(10/11/13) (2:00PM)
- Certificate of Occupancy Walk-Through -

PROJECT: <u>Kitchen</u> <u>City of Portland</u>	LOCATION: <u>99 Waldron Way</u>	CONTRACTOR/VENDOR: <u>L+L</u>	PROJECT #	DATE: <u>10 11 13</u>
--	---------------------------------	-------------------------------	-----------	---------------------------

A1 ARCHITECTURAL ~ PROPOSED FLOOR PLAN
1/8" = 1'-0"

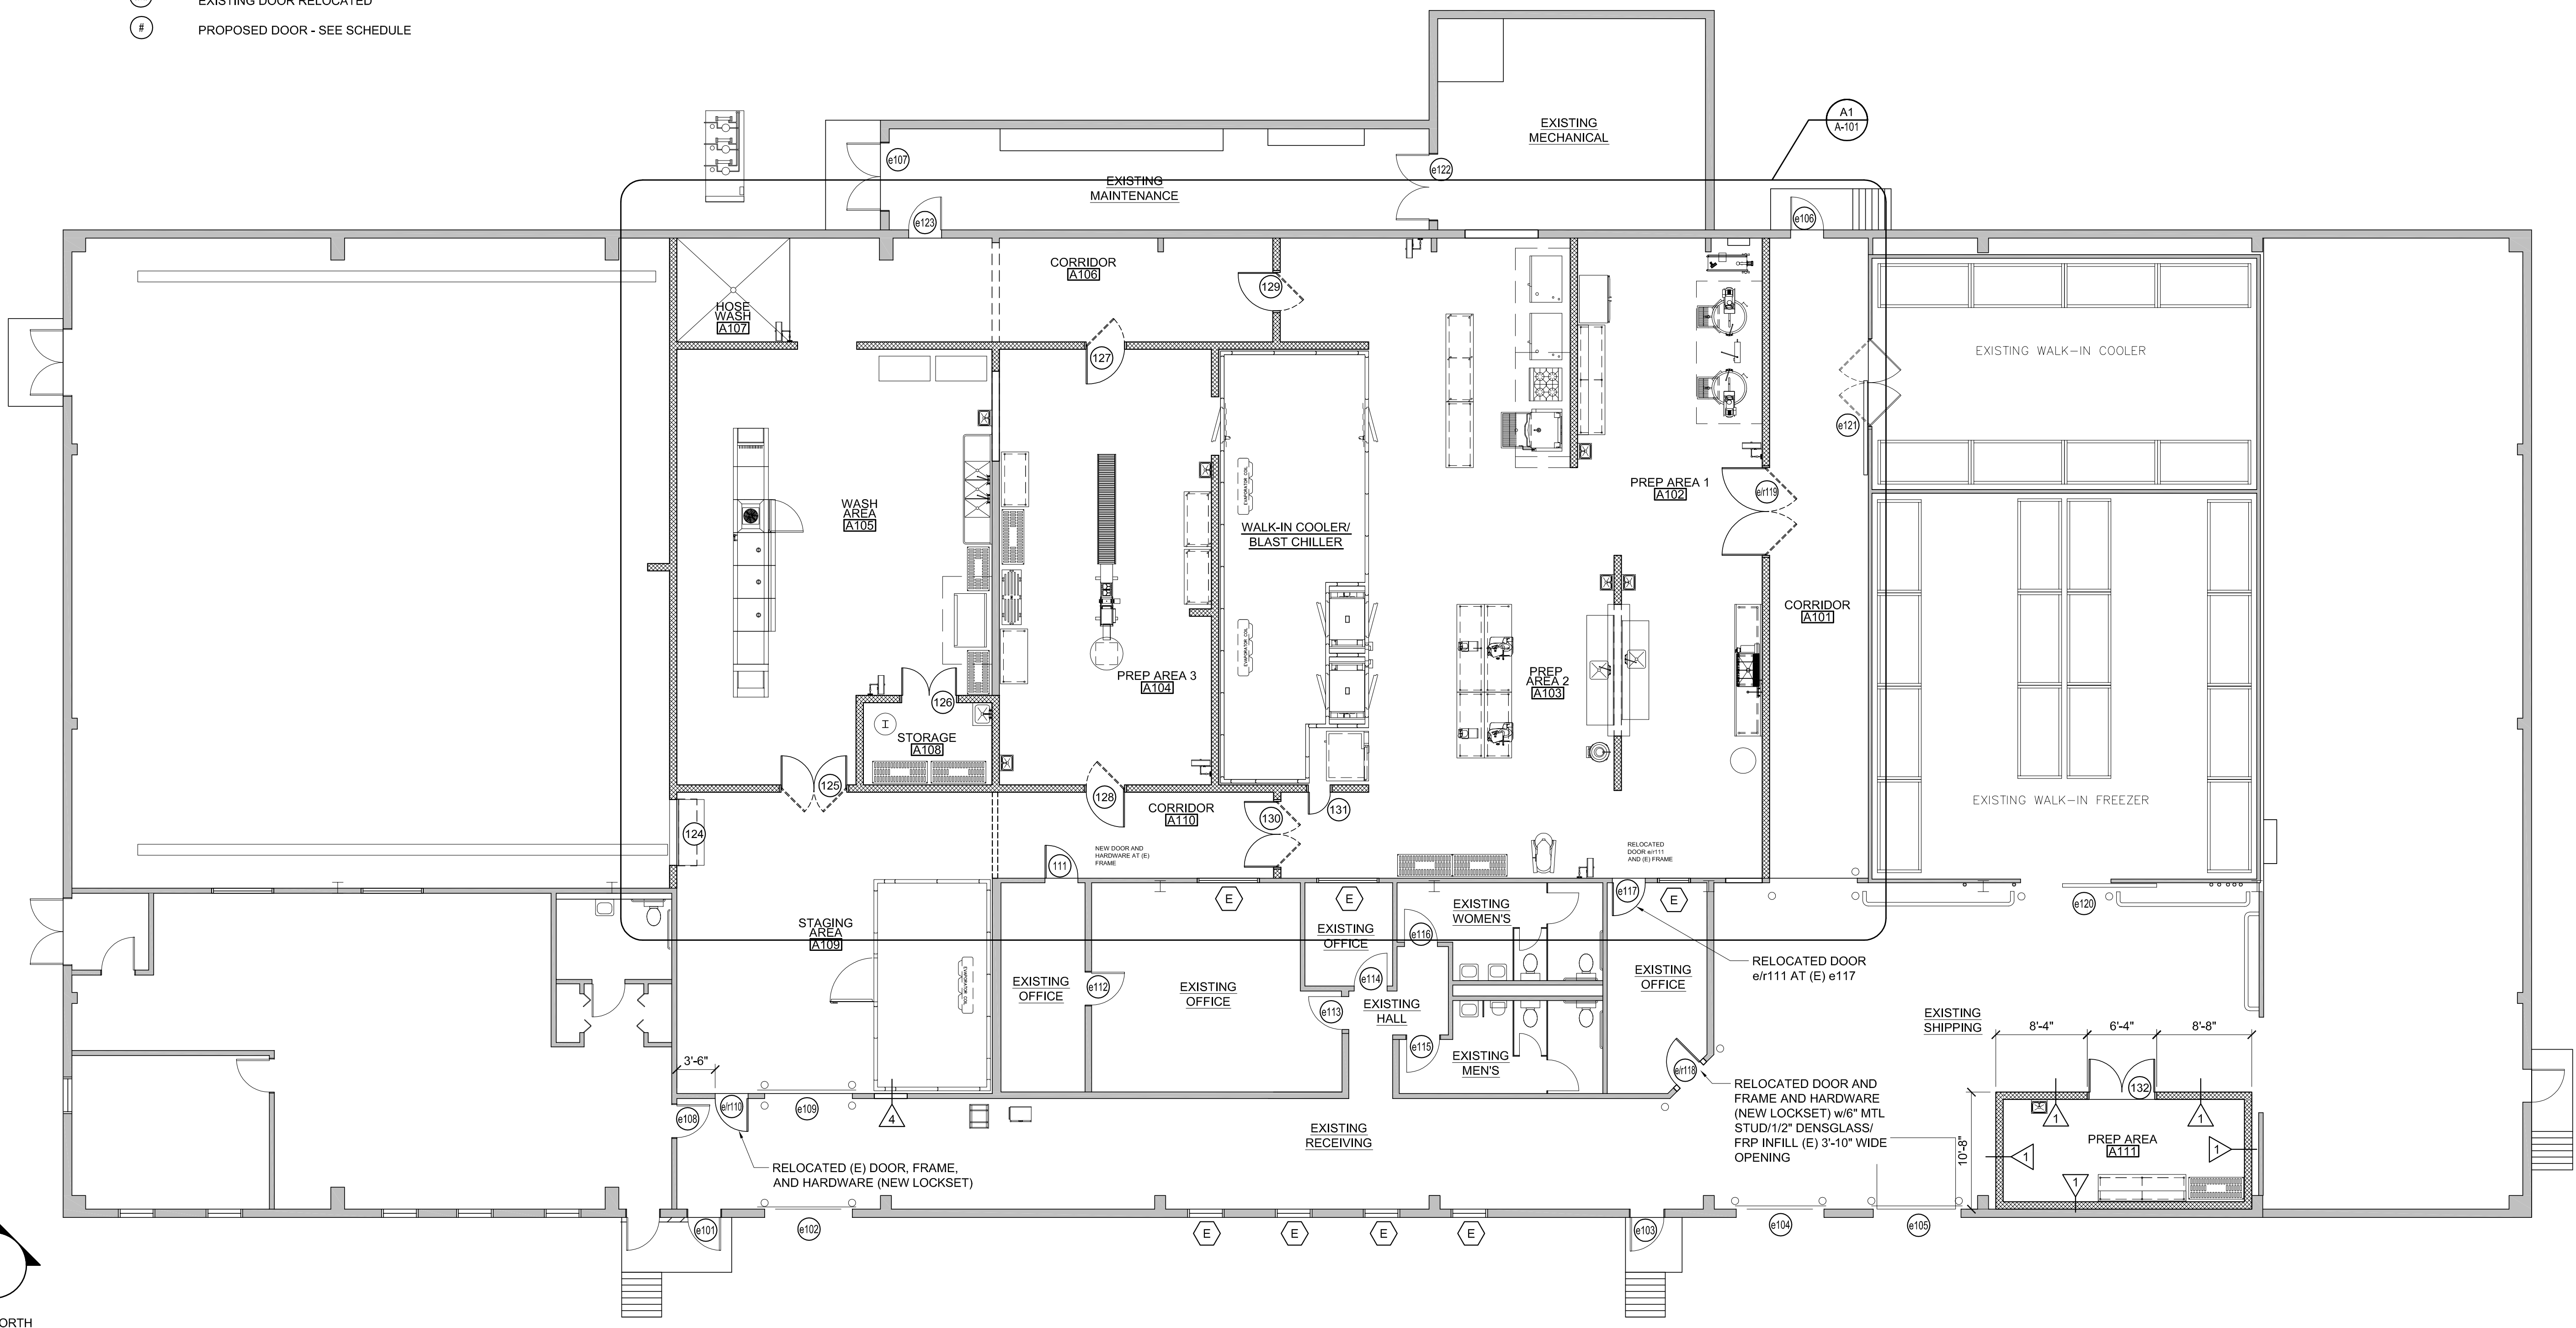
- Codes
- Drywall e separation wall between Mech/Elec. Rooms. Left Side needs Drywall Vertically up to deck if looking from Elec. Room side. There is a gap from where the wall stops to the metal exterior siding. Insulation currently fills this void (not rated).
 - Wants a cut sheet/product data for Foam Insulation used in Mech/Elec. Rooms.

**ELECTRICAL ~ OVERALL BUILDING AND FIRE ALARM PLAN**  
CITY OF PORTLAND  
PORTLAND PUBLIC SCHOOLS - CENTRAL KITCHEN  
92 WALDRON WAY, PORTLAND, MAINE  
© COPYRIGHT 2013 ALLIED ENGINEERING, INC.

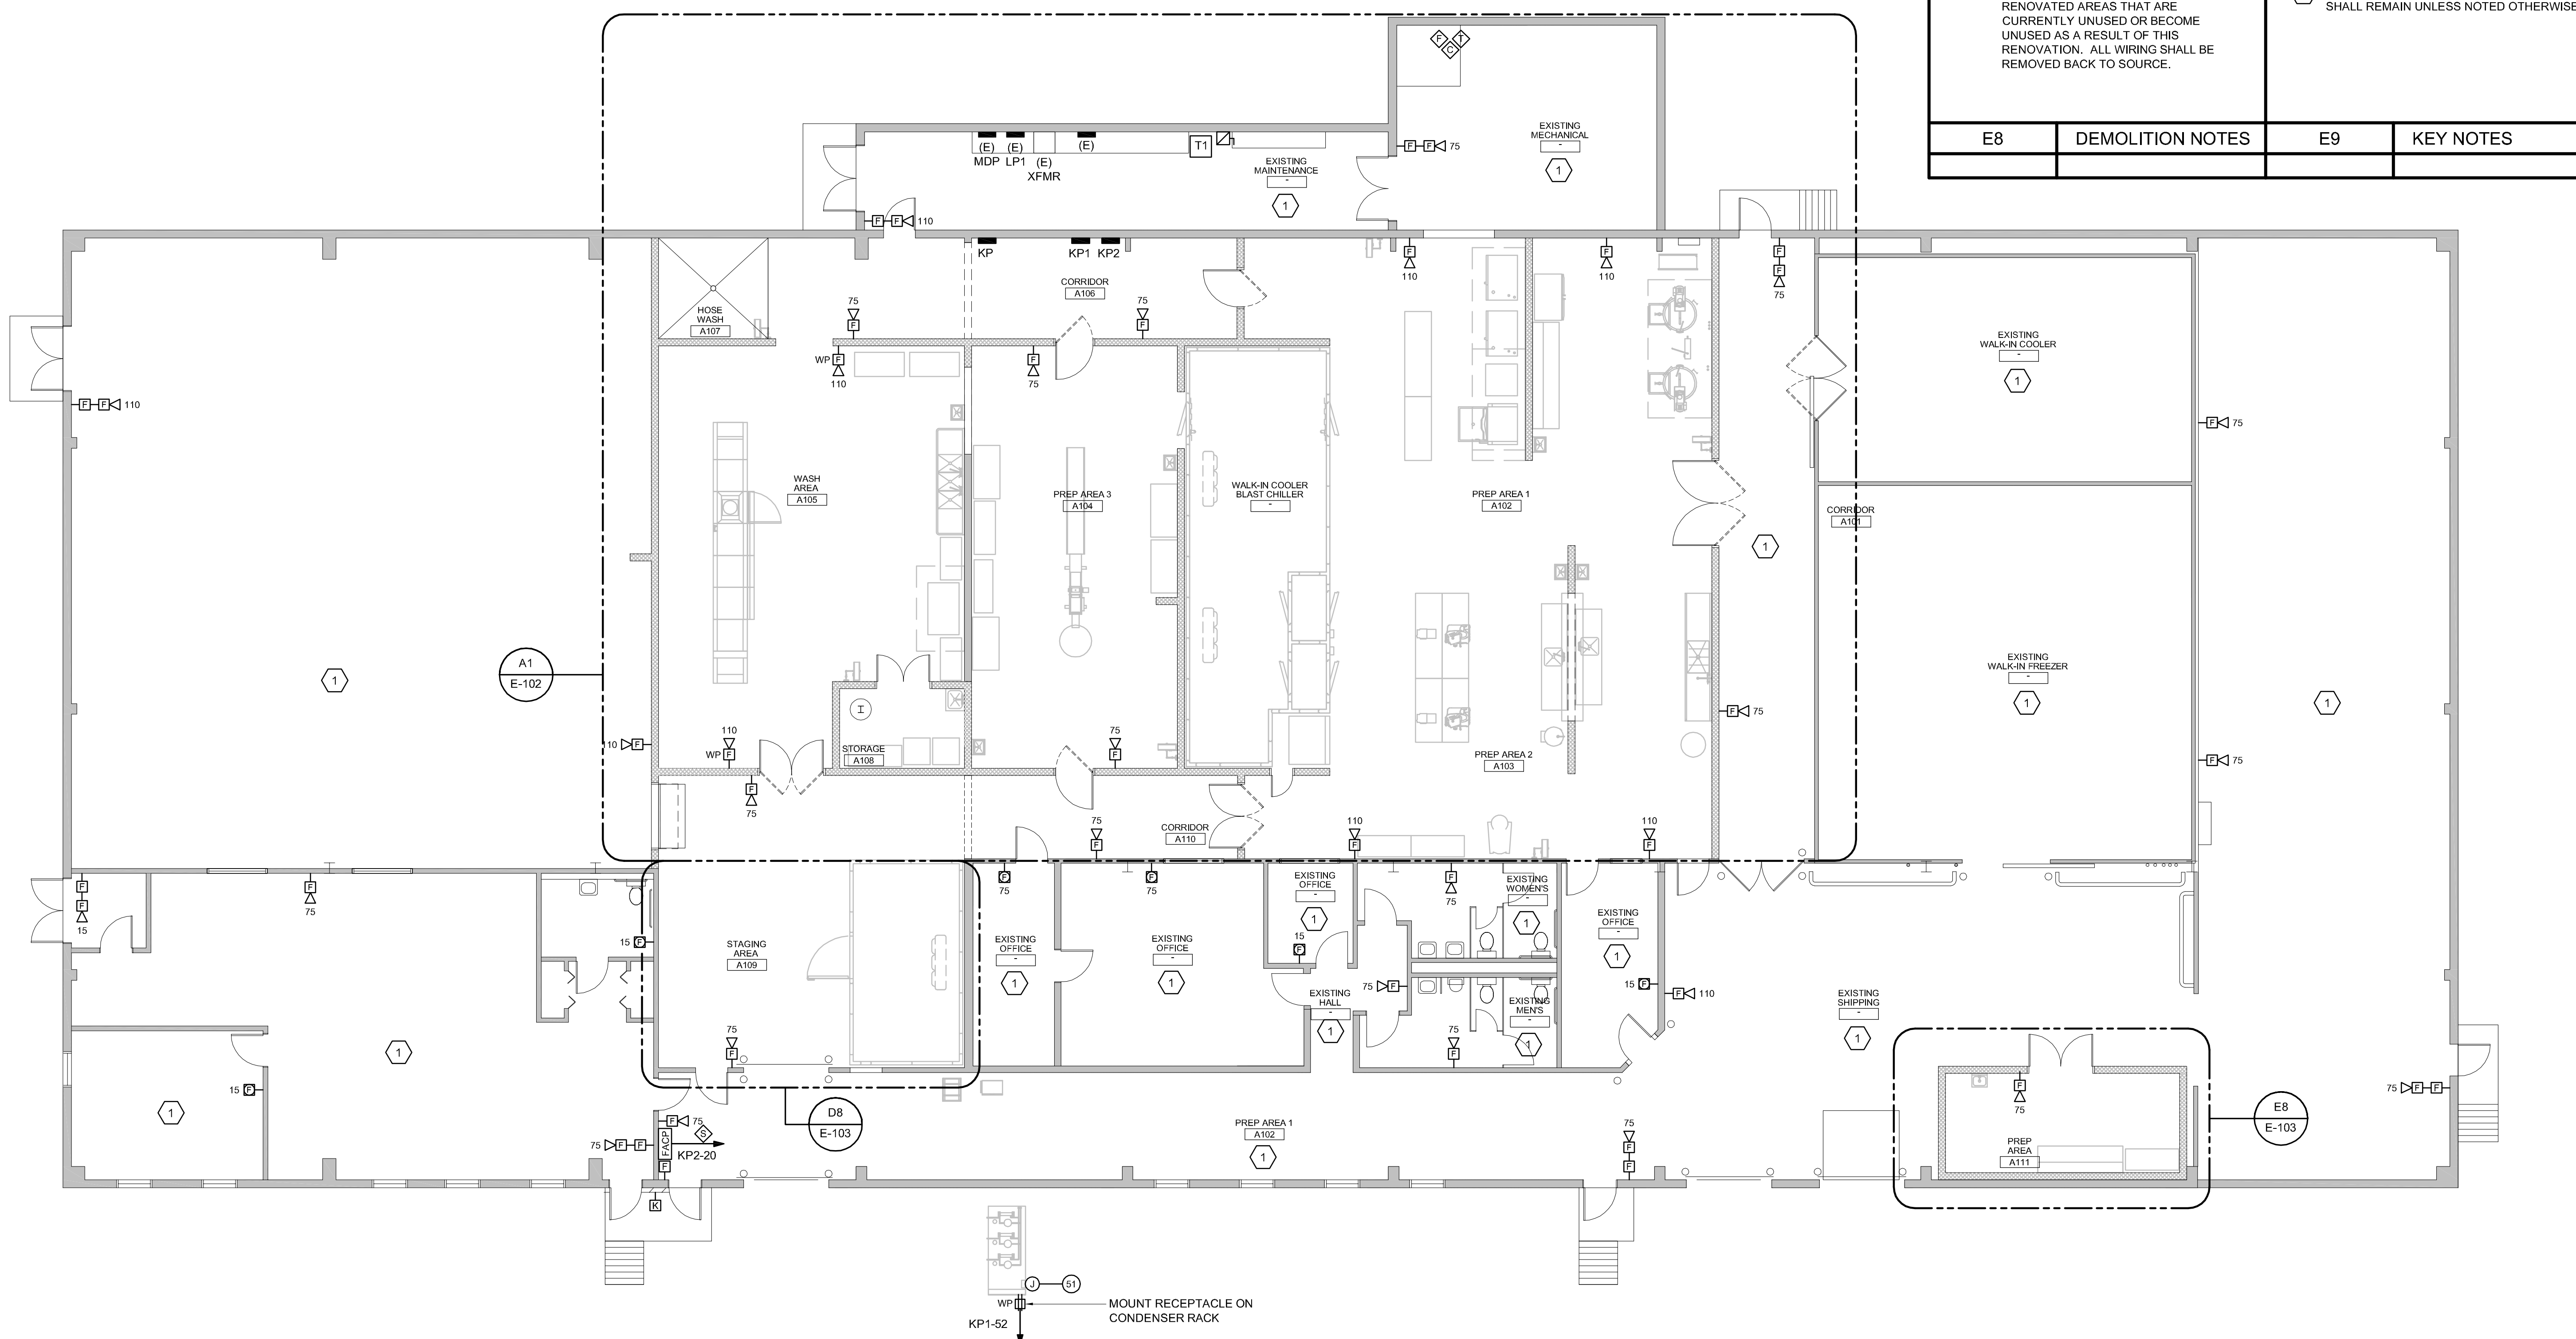
- Electrical
- Conductor Identification on Disconnect (3 Red Wires?)
 - Junction Box Knockouts in Mech. Room
 - Empty Conduits passing through separation wall e Mech/Elec. Room
